Office of
Environment
& Heritage

DOC18/917706
SSD 5175 MOD 5 & SSD 8858

Exhibition of Eastern Creek Business Hub, Rooty Hill Road South, Eastern Creek - SSD 5175 MOD 5 (Concept Plan) and SSD 8858 (Detailed Design) - Lot 1 Stage 2

Attachment 1 – Office of Environment and Heritage (OEH) comments Exhibition of Eastern Creek Business Hub, Rooty Hill Road South, Eastern Creek - SSD 5175 MOD 5 (Concept Plan) and SSD 8858 (Detailed Design) - Lot 1 Stage 2

Figure 12: Pedestrian Access

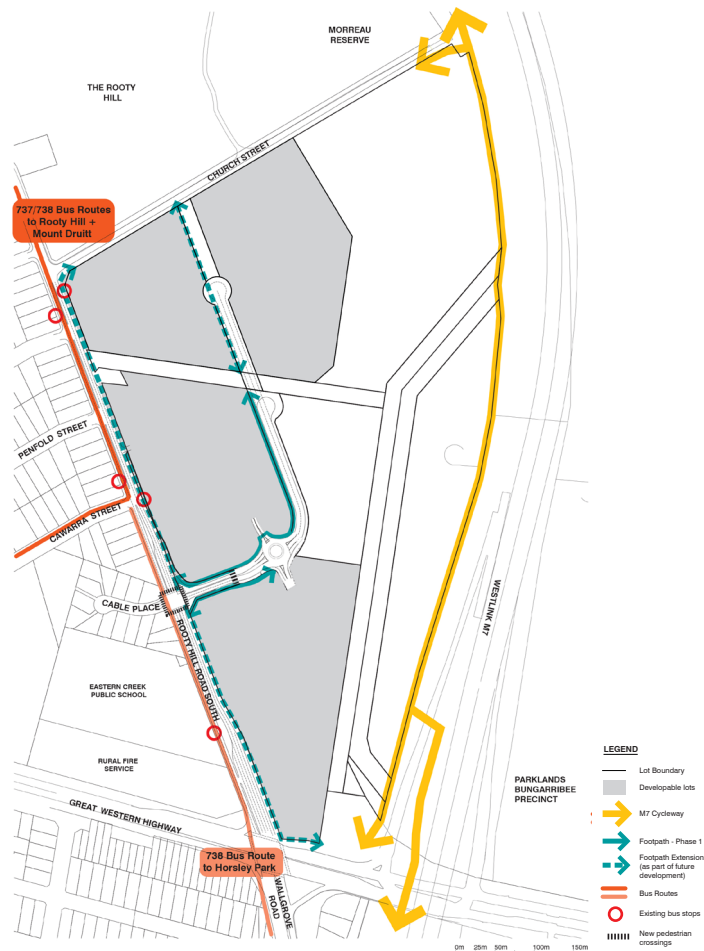
2. The EIS states that “the northern boundary of Lot 1 is proposed to be realigned to facilitate the revised internal access road. As a result, the boundary will no longer be straight, and the landscaped setback will be reduced by up to 5.4m for a small portion of the frontage (Figure 12).” The drainage channel is part of the landscaped setback and more importantly forms part of the proposed on-site offset. This offset area is identified in the design guidelines as Revegetation DNG (Derived Native Grasslands) as shown in light green (Figure 3 below). Clarification is required that the proposed offset is not reduced due to the boundary realignment. Otherwise a Biodiversity Development Assessment Report (BDAR) may be required.

Figure 51: Development Control Plan - Lot 1 (not to scale)

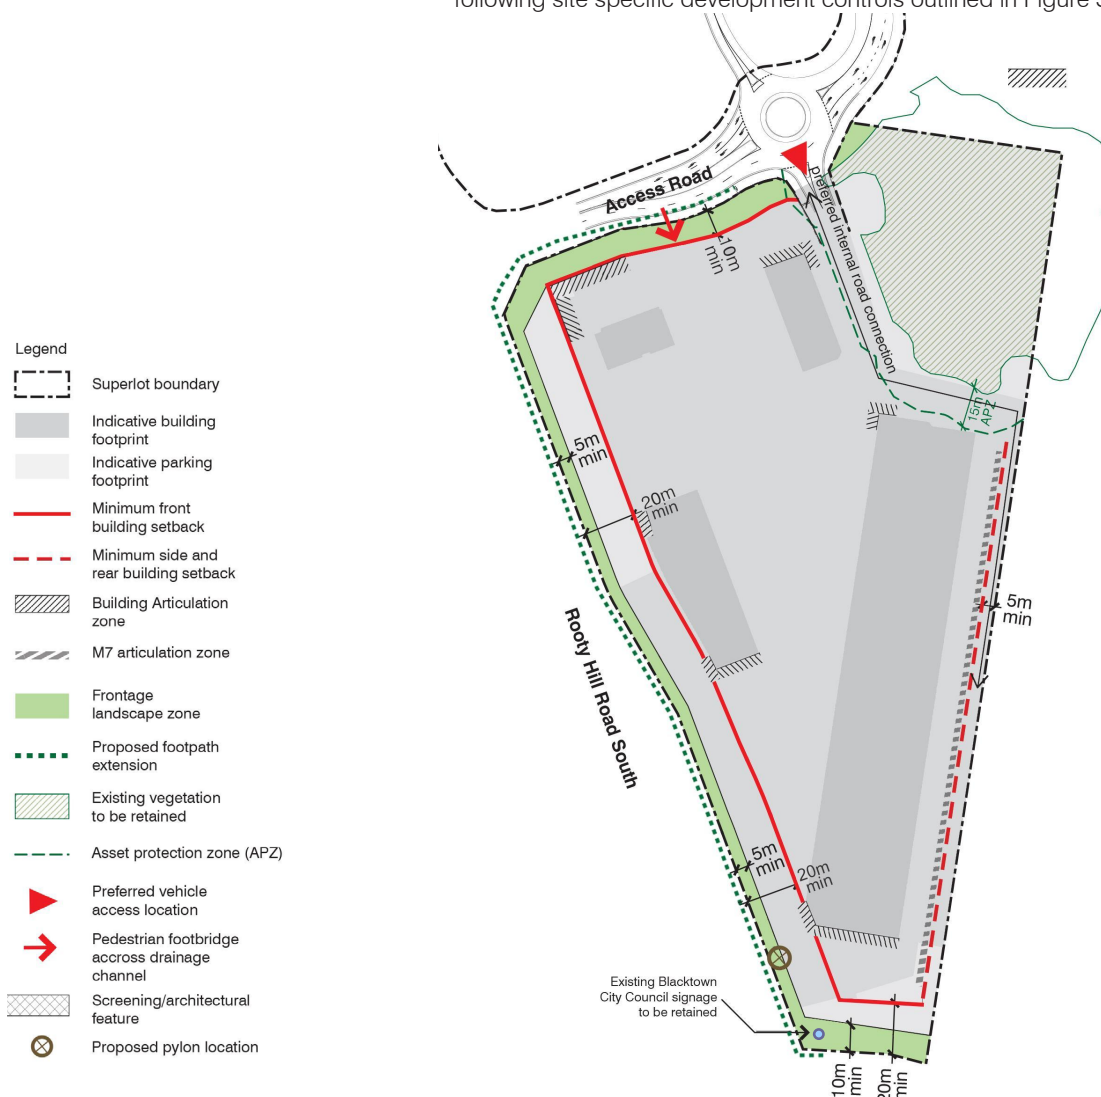
1. The main potential biodiversity impact of this modification is in relation to the new internal access road and roundabout as shown on Figure 51 – Development Control Plan Lot 1. The preferred internal road connection impacts on a small portion of vegetation that is identified as ‘existing vegetation to be retained’ and which forms part of the offset for the site. The impacted area is highlighted in yellow on the extracted map below – Figures 1 and 2 below.

Given this impact, a BDAR will need to be submitted with the SSD 5175 MOD 5. Alternatively, the plans need to be revised to ensure the internal road does not impact this vegetation. OEH cannot grant a BDAR waiver for a modification that has an increased impact on biodiversity values under (s30A(2) Biodiversity Conservation(Savings and Transitional) Regulation 2017).
